Planning Inspectorate

Our Ref: EN010155

Application by FVS Dean Moor Limited for an order granting development consent for the Dean Moor Solar Farm project (EN010155)

Advice following issue of decision to accept the application for examination

DEAN MOOR SOLAR FARM
DEVELOPMENT CONSENT ORDER
REGULATION 5(2)(O)
Traffic Regulation Measures Plan

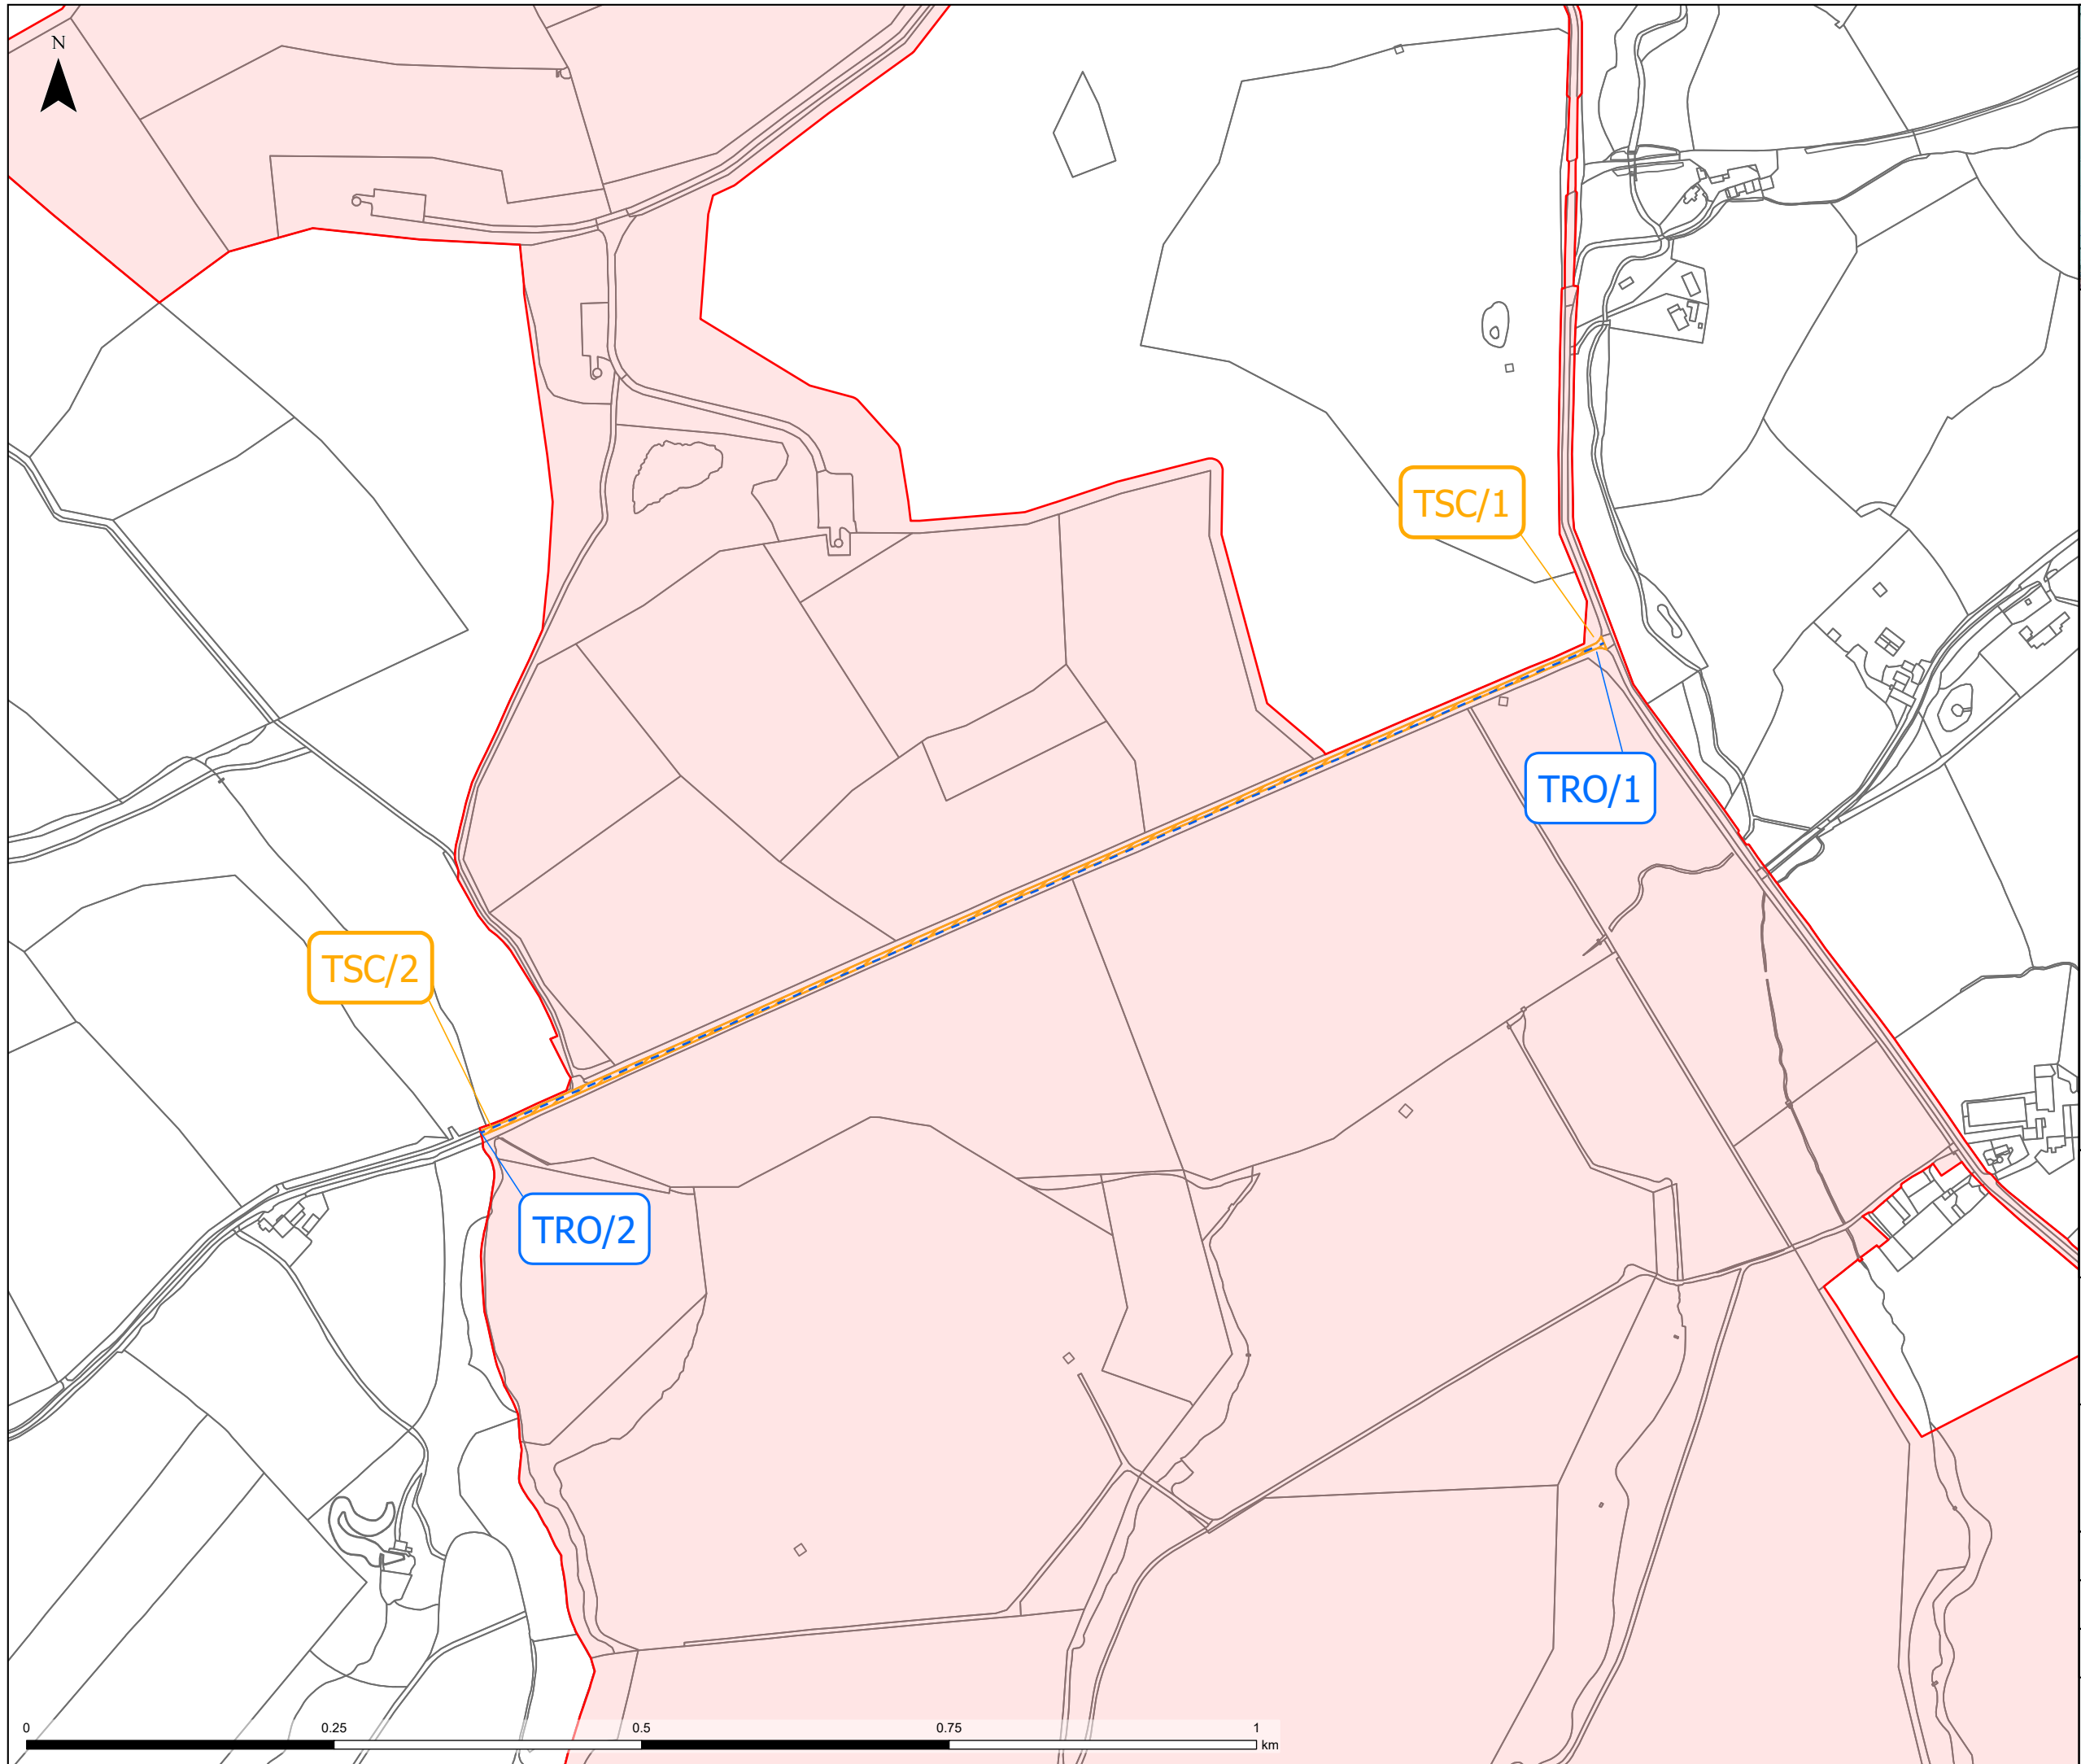
Traffic Regulation Measures Plan (Doc 2.5)

The plan does not have any road names as identified in the dDCO.

Schedule 6 of the dDCO states points TSC/1 and TSC/2 hatched yellow on the plan, but the colour on the plan is orange.

DEAN MOOR SOLAR FARM
DEVELOPMENT CONSENT ORDER
REGULATION 5(2)(K)
Streets and Access Plans
Version 2

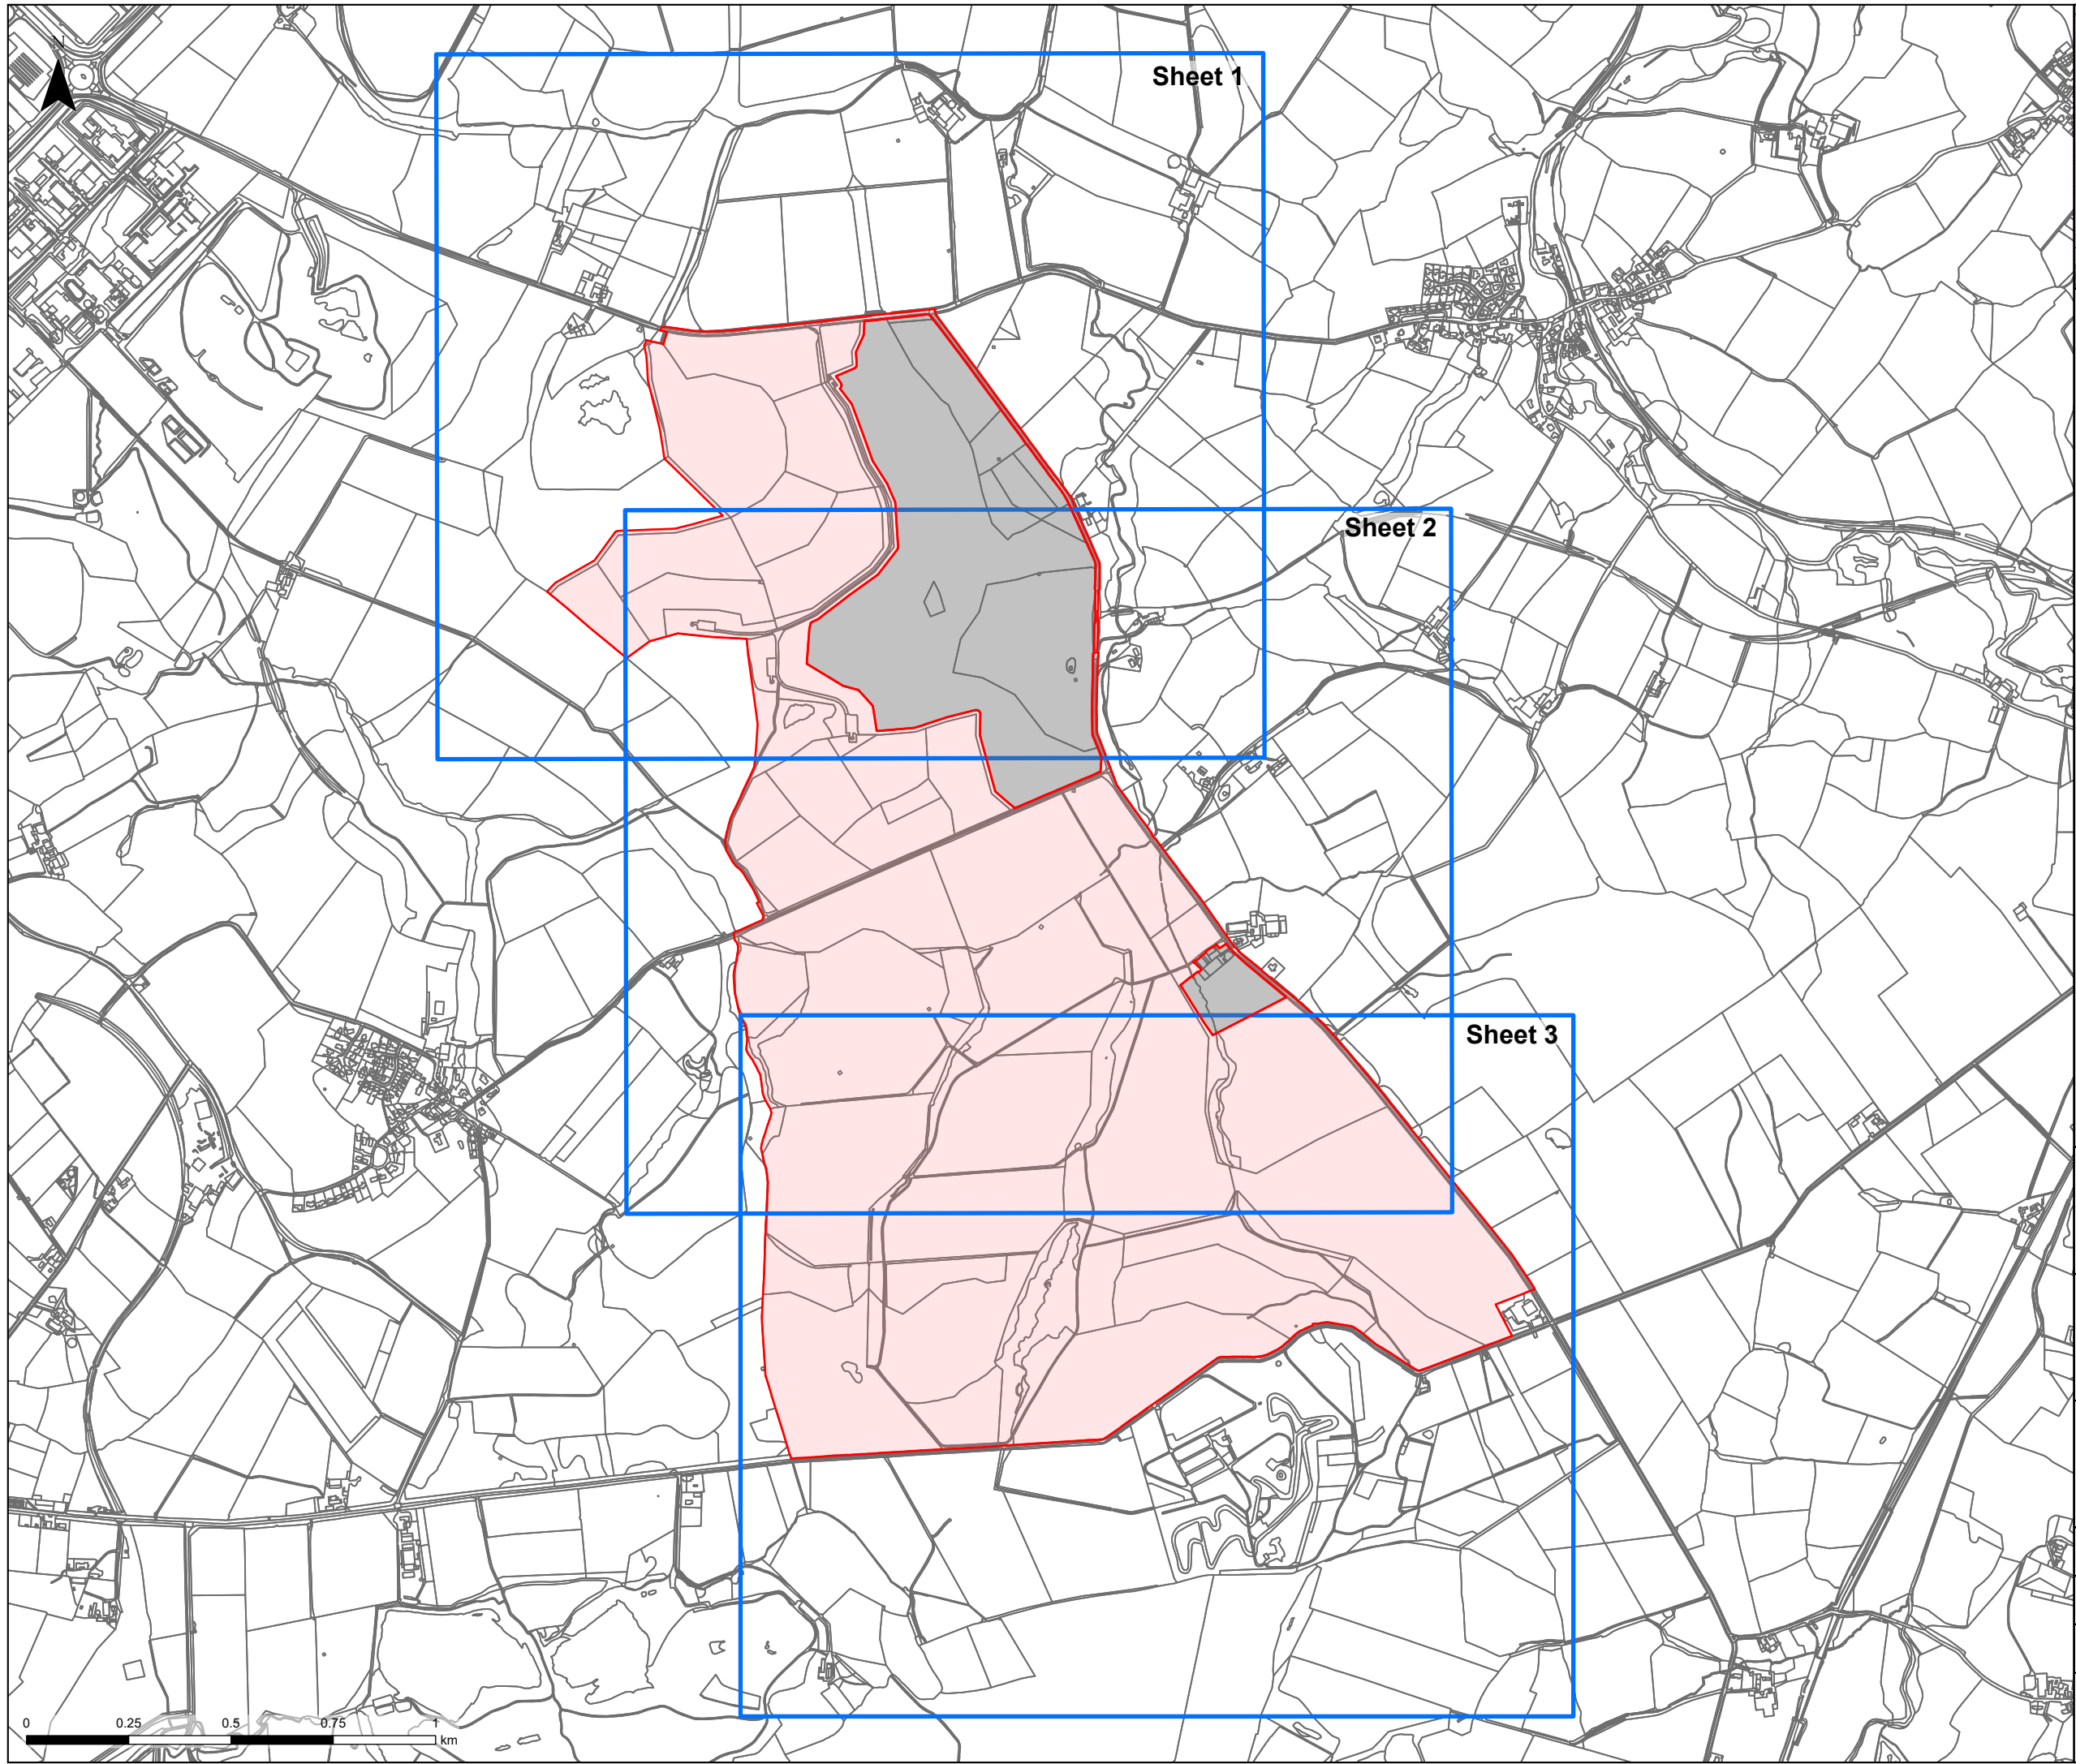
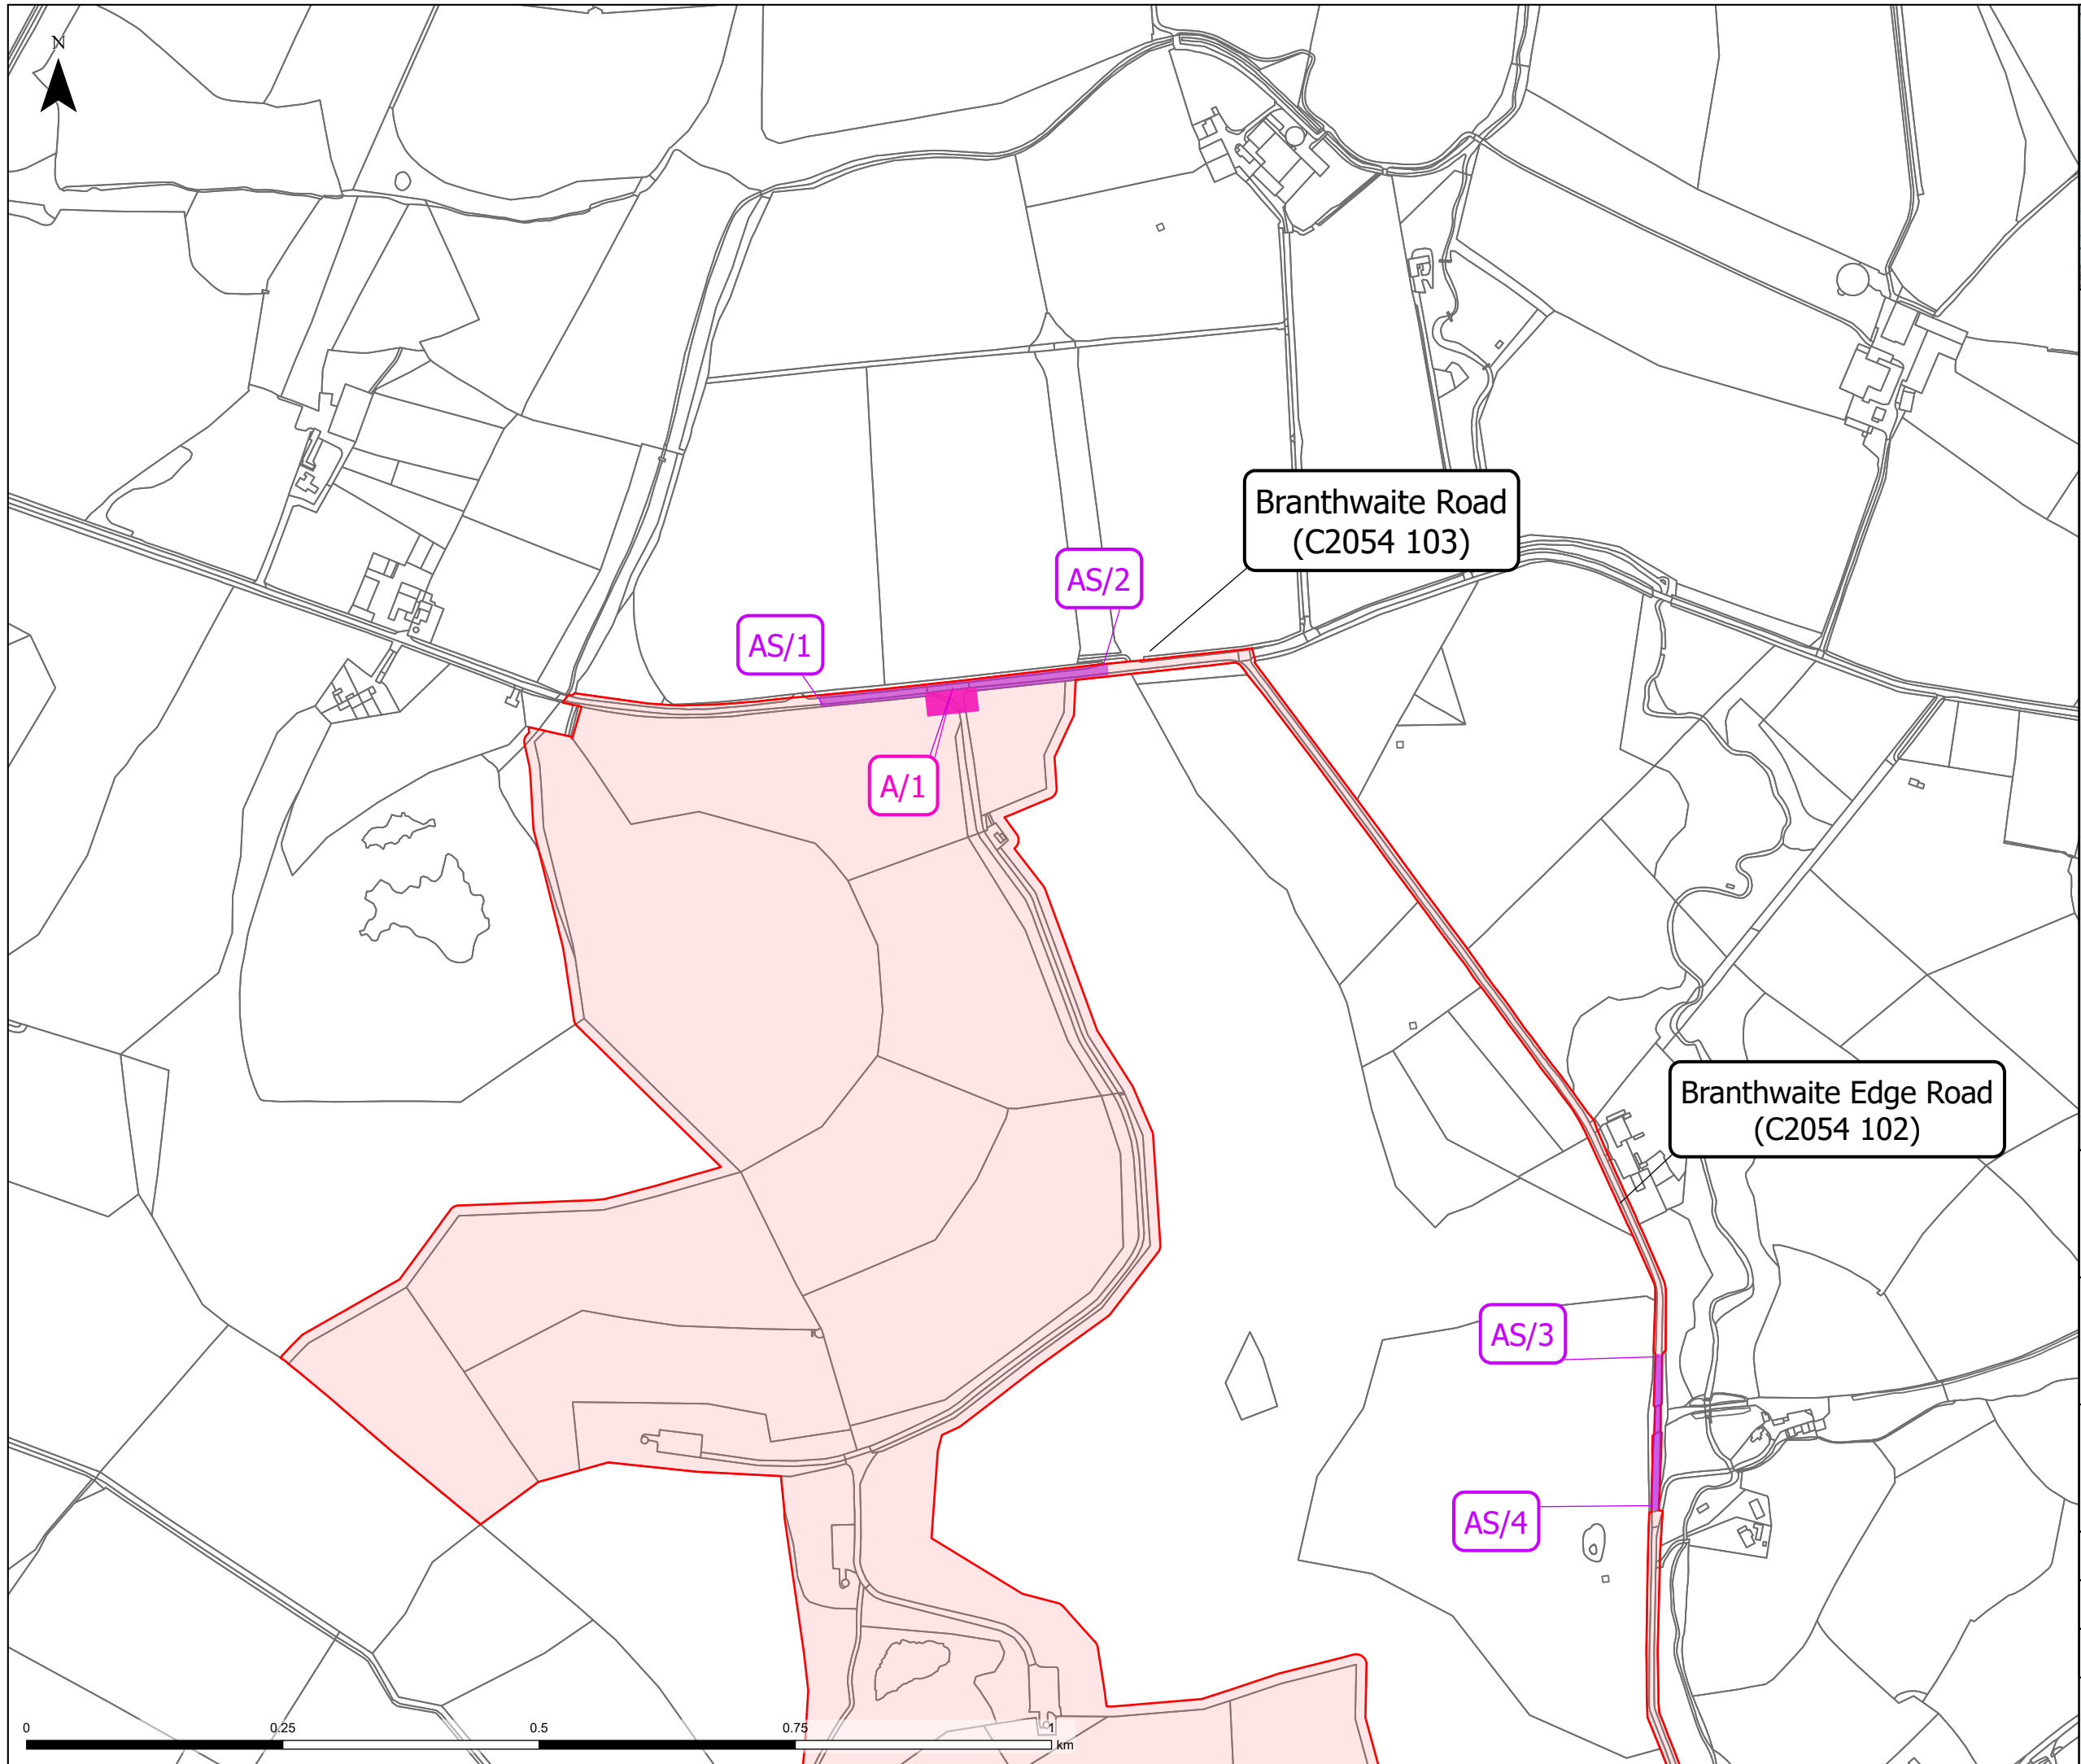
Streets and Access Plans (Doc 2.4)

The plans do not have any road names as identified in the dDCO.
